Application No: Y/5/26/PL
Site Address: 2 Downview Road Yapton BN18 0HS
Description of works: Erection of terrace of 4 No town houses with gardens and parking spaces. This application is in CIL Zone 2 and is CIL Liable as new dwellings.

Thank you for your internet representation made on 26th March 2026 which has been recorded as an objection with the comments as follows:

2 Downview Road, Yapton : Proposed 4-unit 3-storey Terrace of 3-bedroom Dwellinghouses : PROPOSED SITE LAYOUT

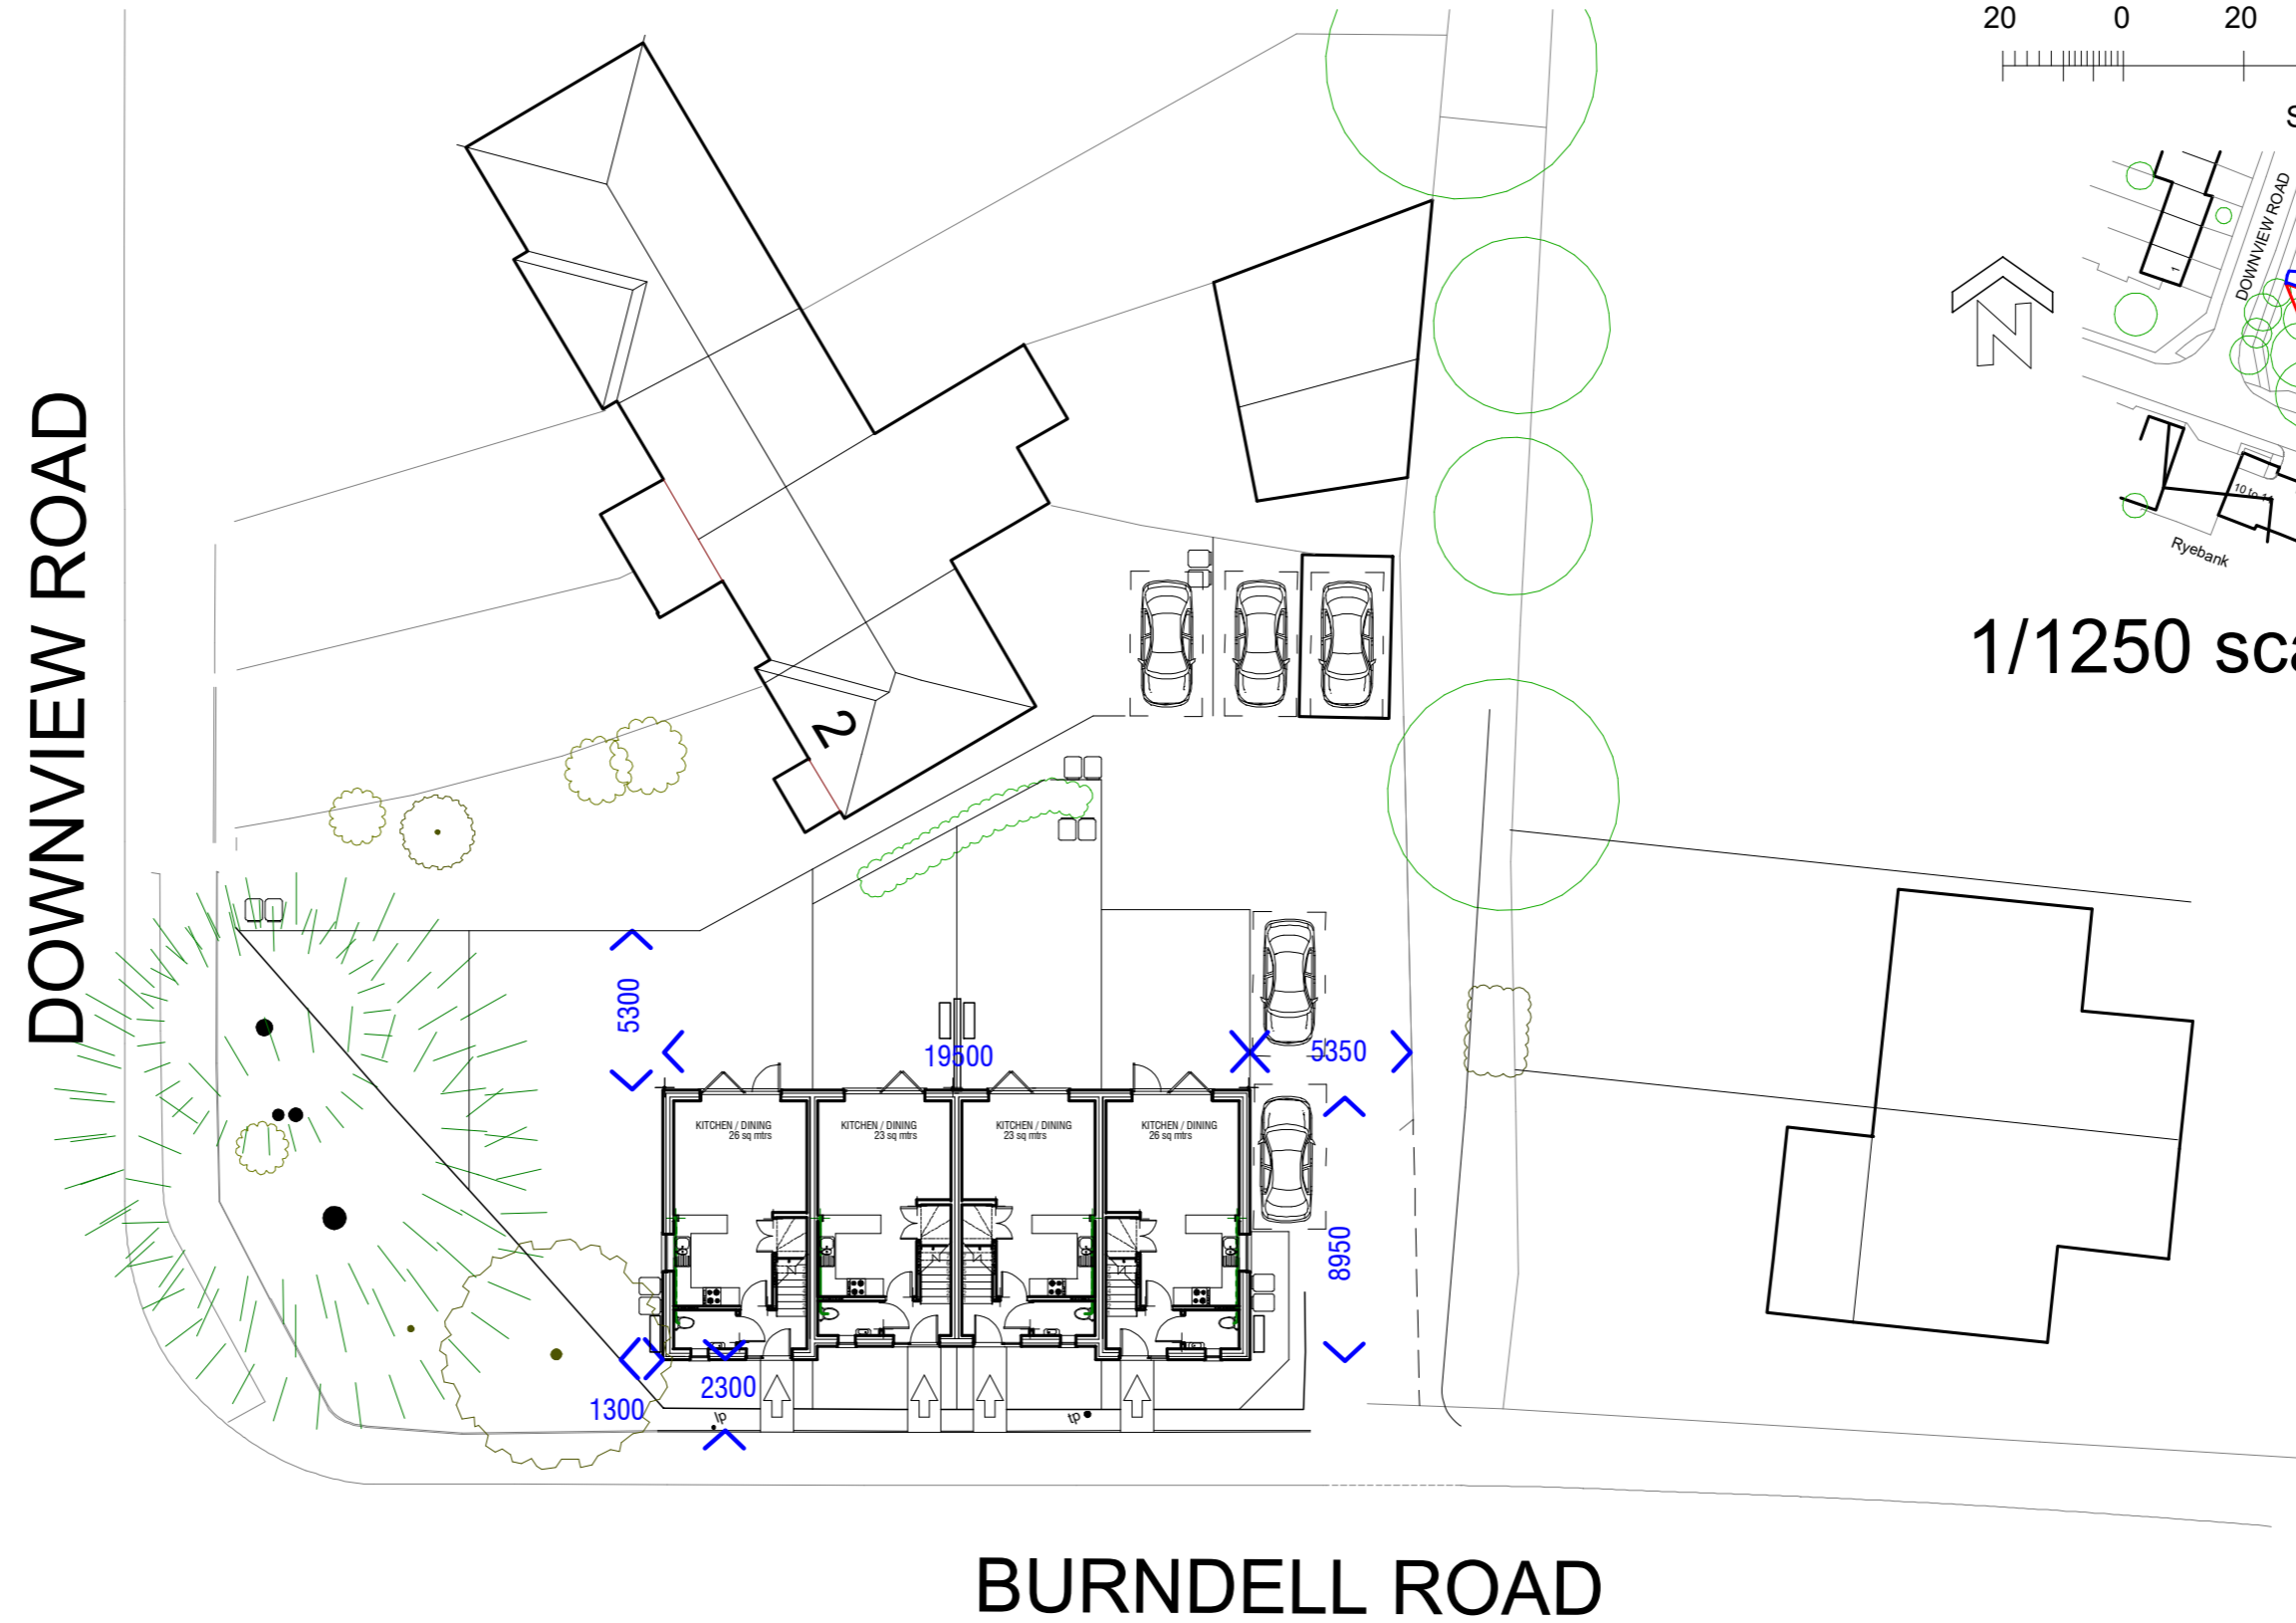
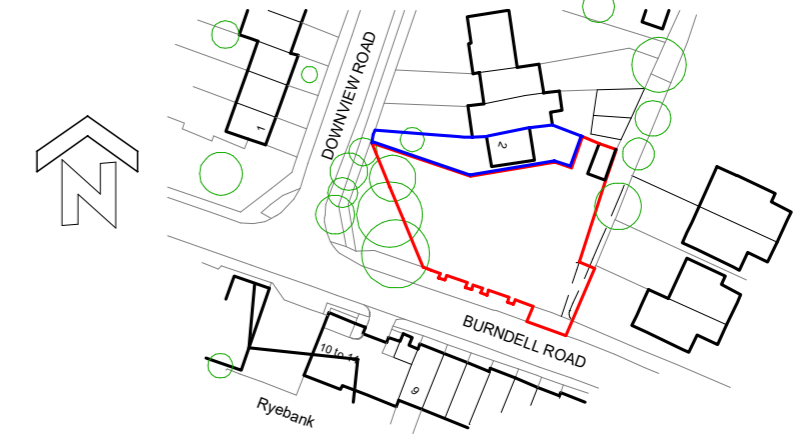
They are too near the road.

They have insufficient parking spaces allocated to them (only one per house),

The access to Burndell Road from the parking spaces is highly dangerous due to the high brick wall to the east of the sight that extends to the pavement.

The loss of visibility for egress from Downview Road which has already been reduced by the recent erection of the six foot high fence would worsen and increase the danger of collisions.

2 Downview Road, Yapton : Proposed 4-unit 3-storey Terrace of 3-bedroom Dwellingshouses :
PROPOSED ELEVATIONS and SECTIONS

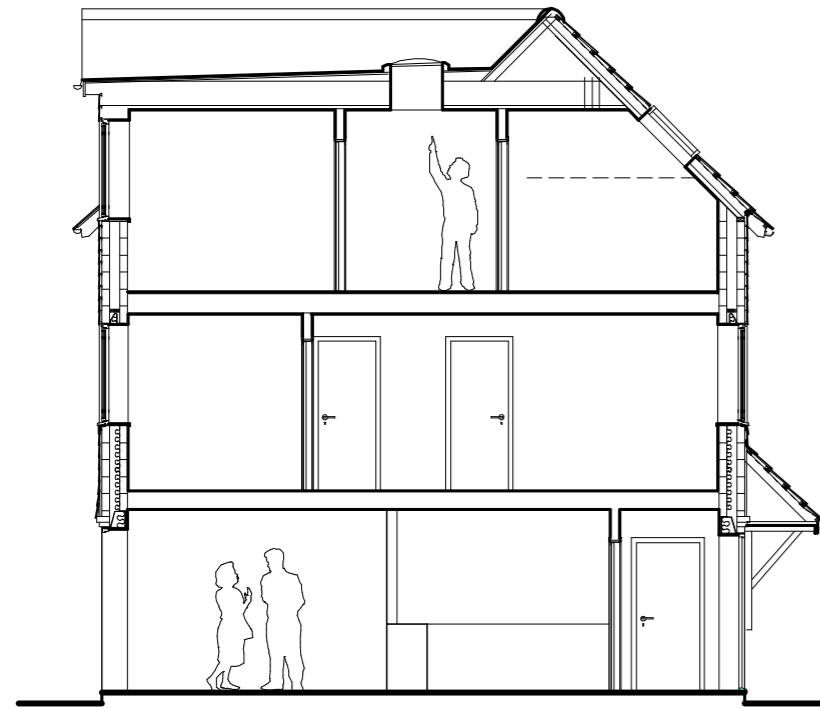
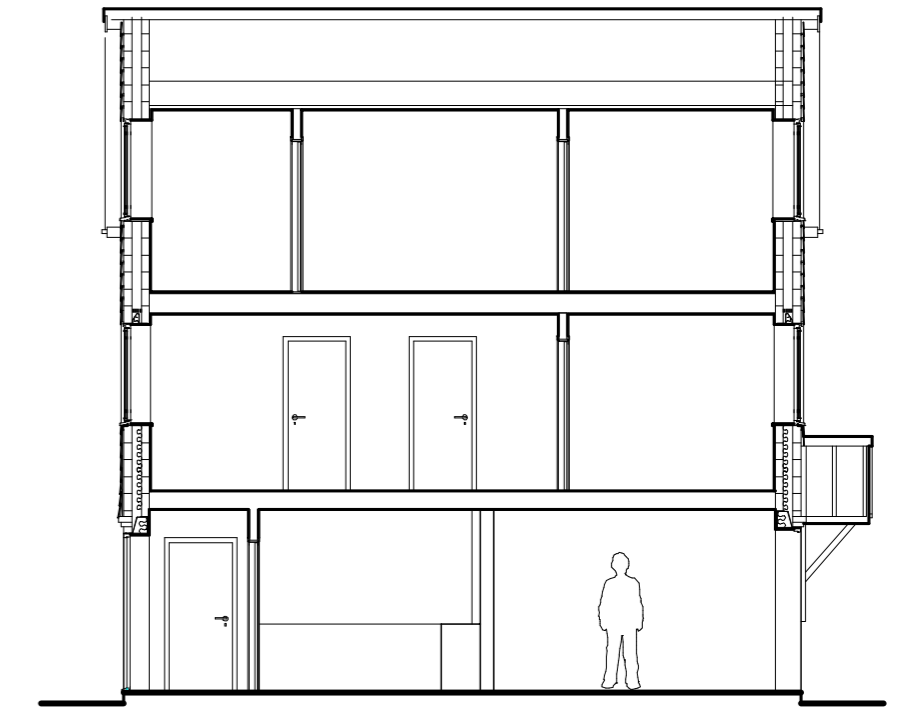
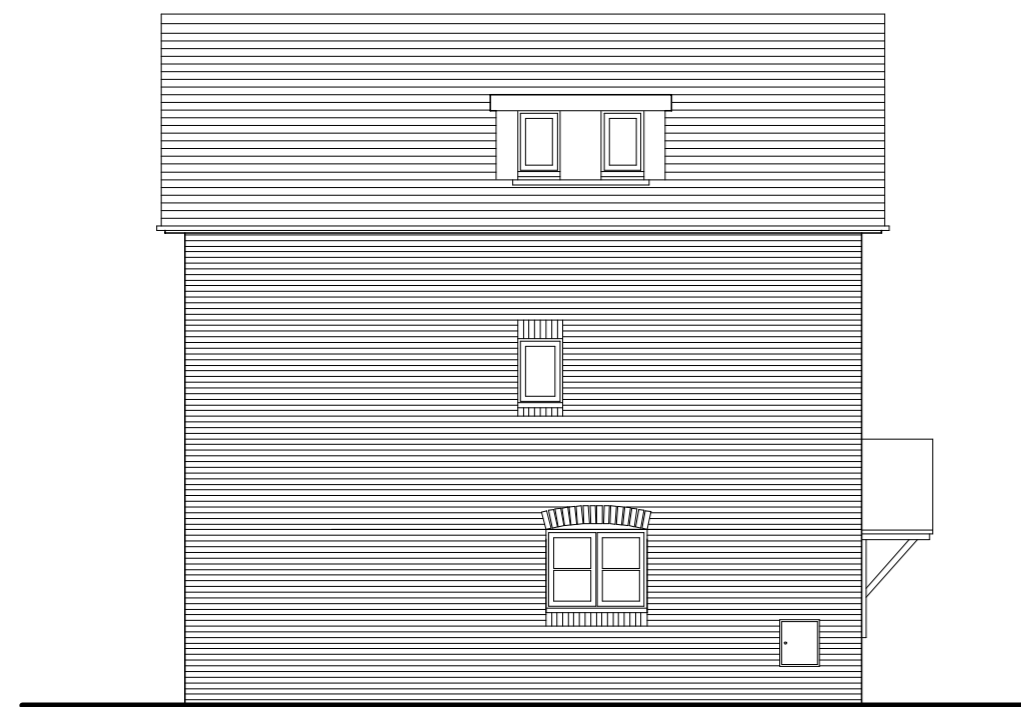
The proposed houses being immediately to the south of No.2 Downview Road would be too high to allow enough light into No.2 and would cast its garden in shade.

They would overlook the flats opposite and No.2 reducing the privacy of neighbours.

The height and massing of the proposed houses.
